# Consultee Comments for Planning Application 21/02051/FUL

Application Number: 21/02051/FUL

Address: 1 & 2 Pavilion Spring Valley Lane Ardleigh Essex CO7 7SD

On Behalf Of: Tree & Landscape Officer

LANDSCAPING PLAN for proposed replacement of No 1 & No 2 The Pavilion with a two bedroomed single story residential dwelling on land adj Woodland Lodge Spring Valley Lane Ardleigh Colchester CO77SD

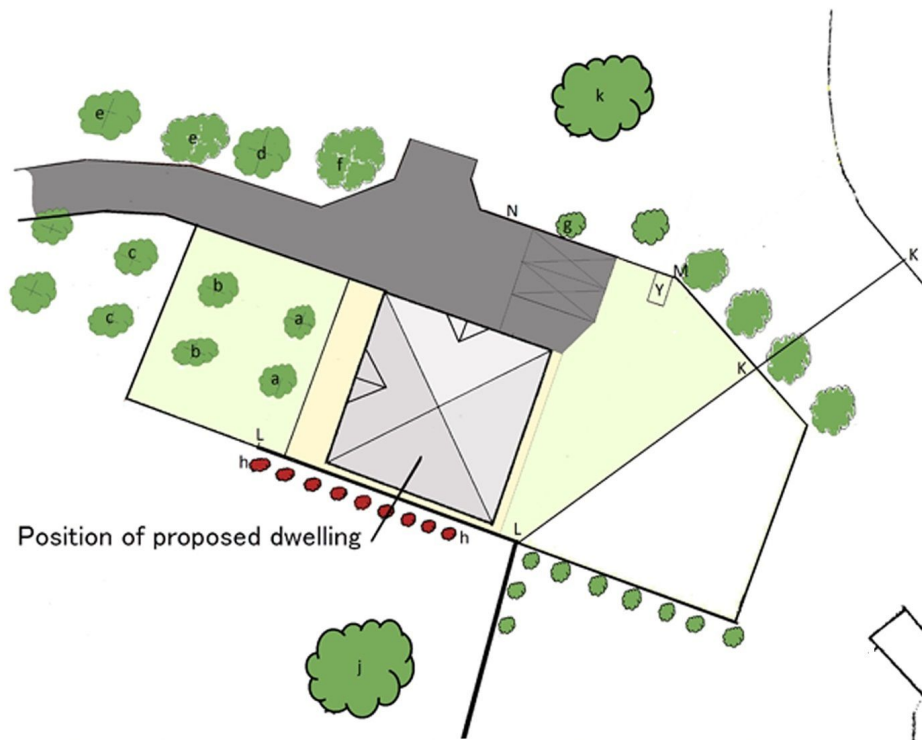
In this case it appears that there is satisfactory separation between the position of the proposed dwelling and the wood and that the development proposal contained in the current application would not be likely to adversely affect the wood.

Nevertheless it will be necessary to ensure that the buffer zone is not compromised by the development, by vehicular movements or other works, associated with any development that may be granted planning permission. The physical protection of the buffer zone should be secured by a planning condition.

In terms of the impact of the proposed dwelling on the character and appearance of the countryside, and taking into account the proposed demolition of an existing building: it is considered that a combination of the existing screening provided by the wood and new screening on the southern boundary, that should be secured by a planning condition, means that the dwelling would not have a visually intrusive impact on the appearance of the countryside.
